March 25, 2024

G-5861

Subject: Geotechnical Review of Proposed Heated Geo-Slab Foundation System
Proposed Residence
3632 – 90th Avenue SE
Mercer Island, Washington

1 FOUNDATION AND FIRST FLOOR PLAN
S2.1 1/4" = 1'-0"

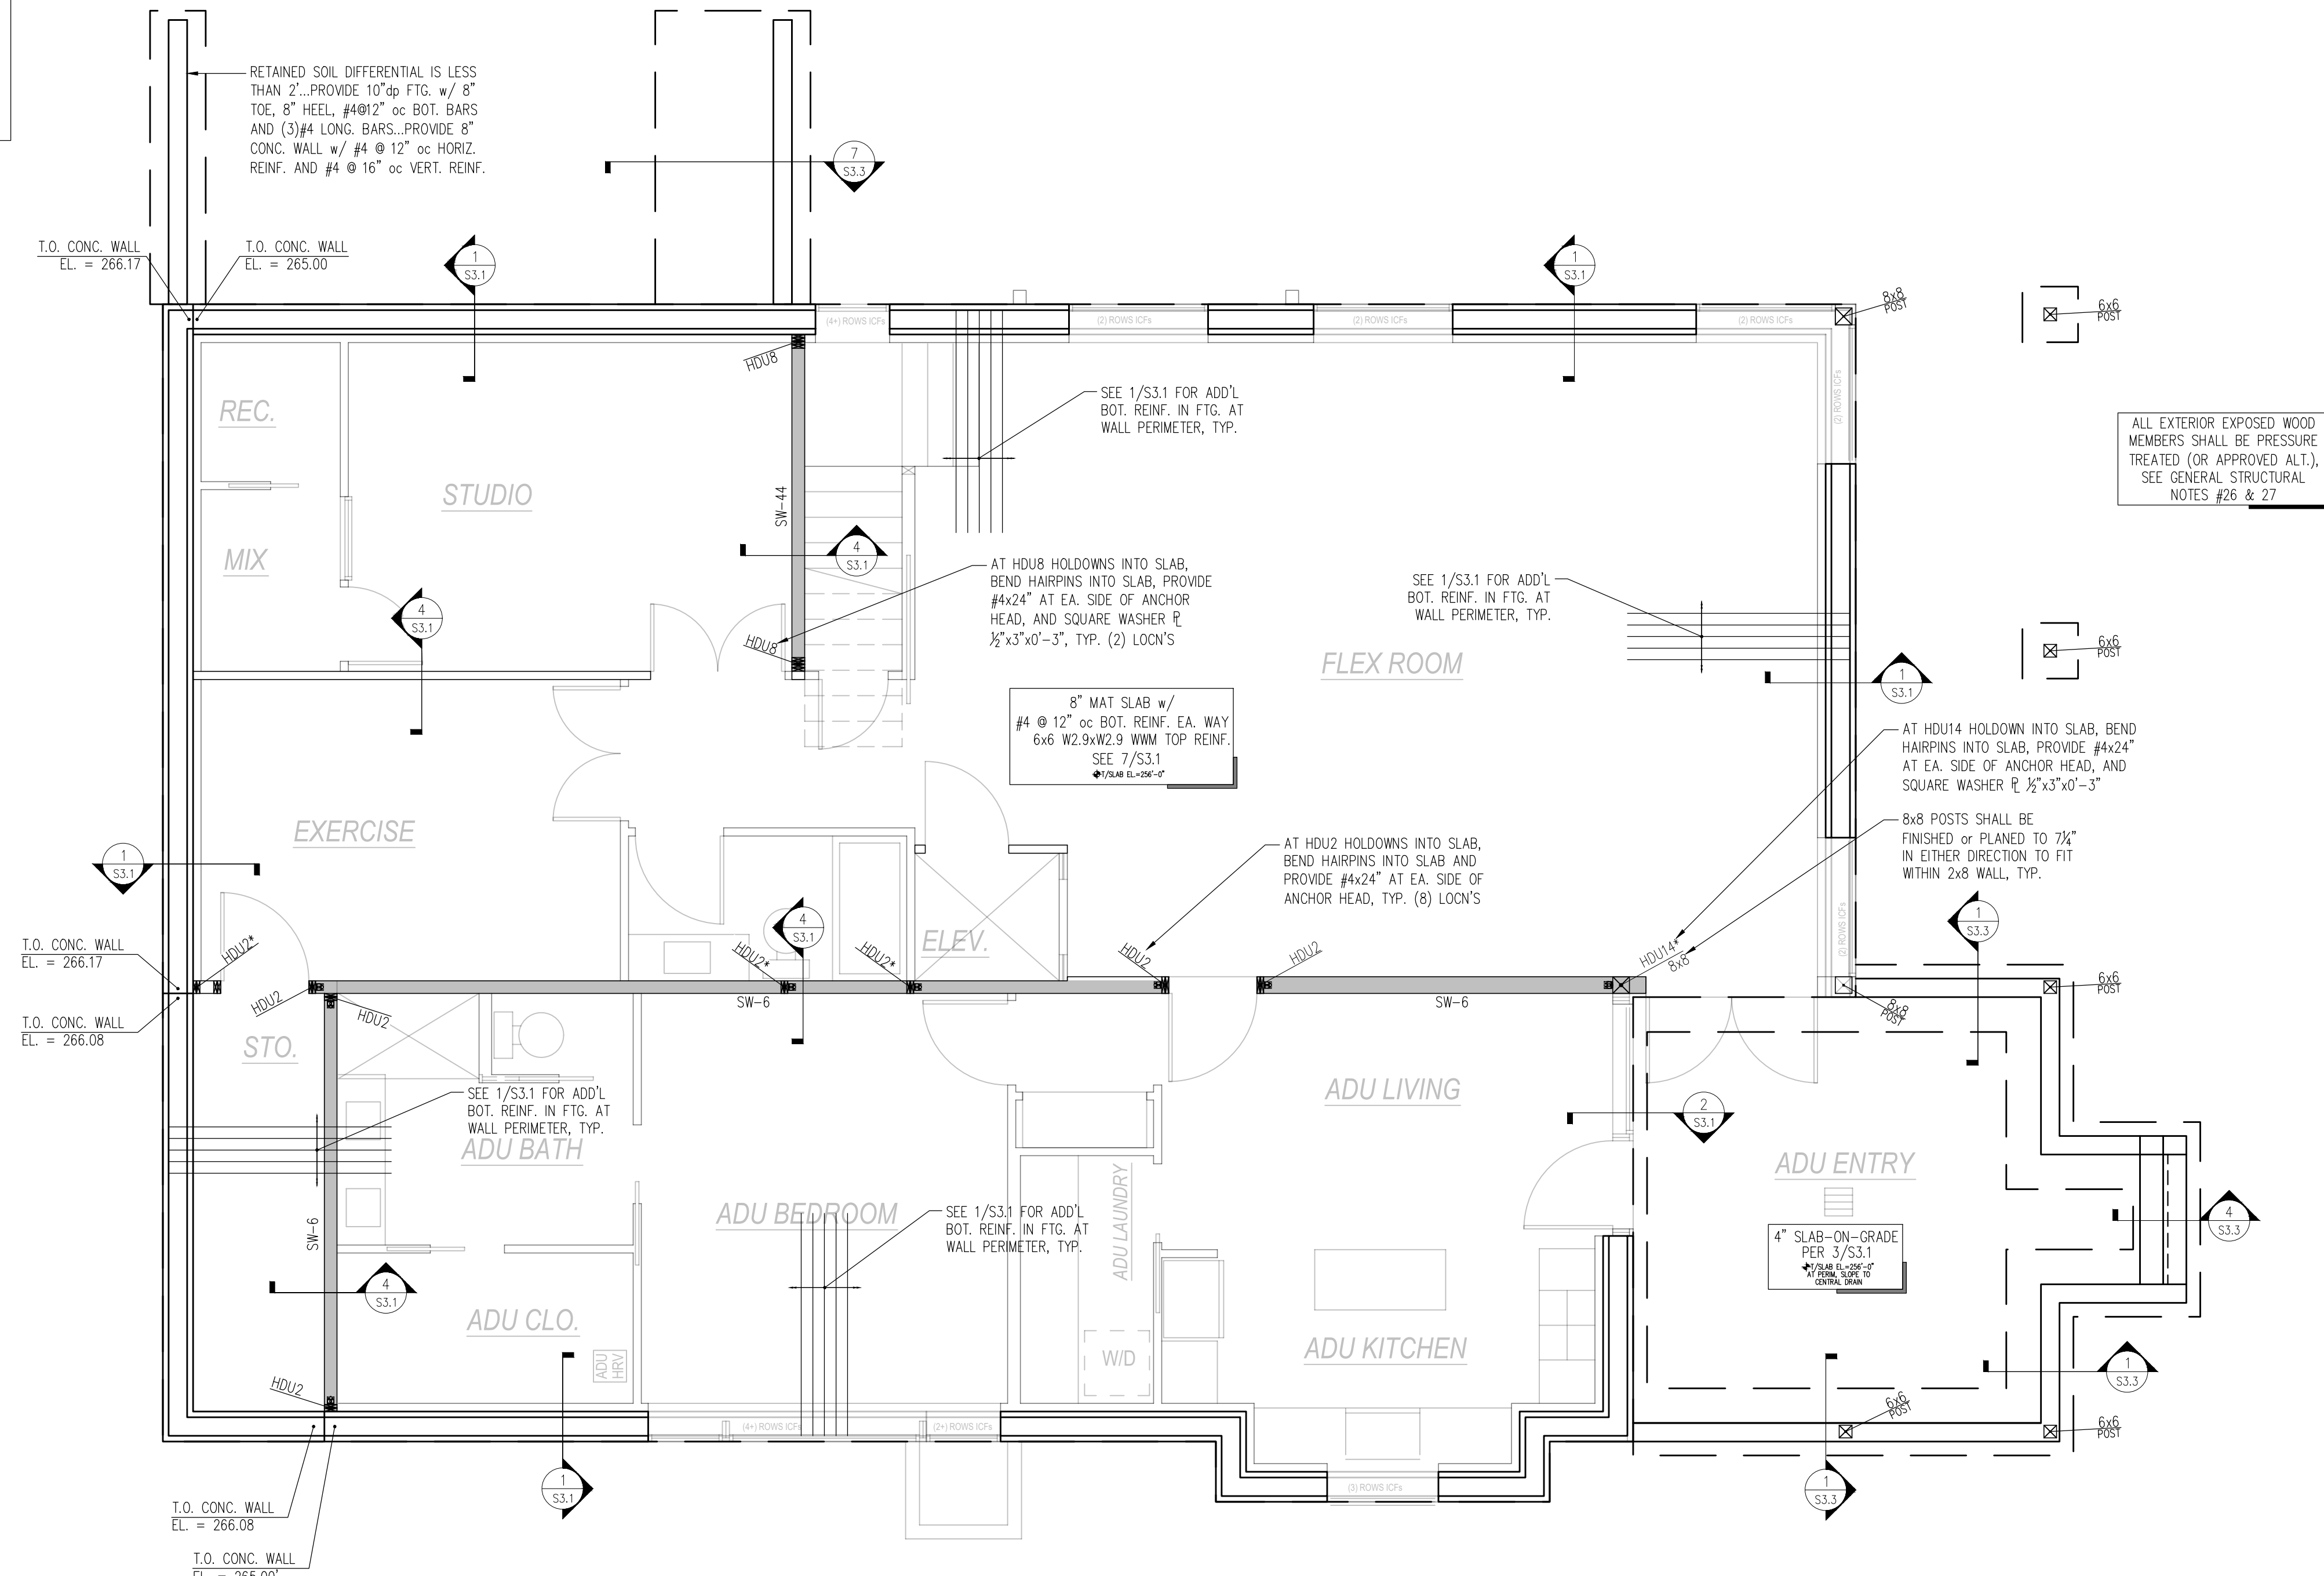
In our opinion, the proposed foundation system as specified in the enclosed plans is acceptable for the project from a geotechnical perspective, provided that the building slabs have a minimum thickness of 8 inches at structurally-loaded locations. We also recommend that the footing drains for the new residence be incorporated into the design for the foundation system either below or beyond the outer limits of the geofoam skirting that is illustrated in the plans.
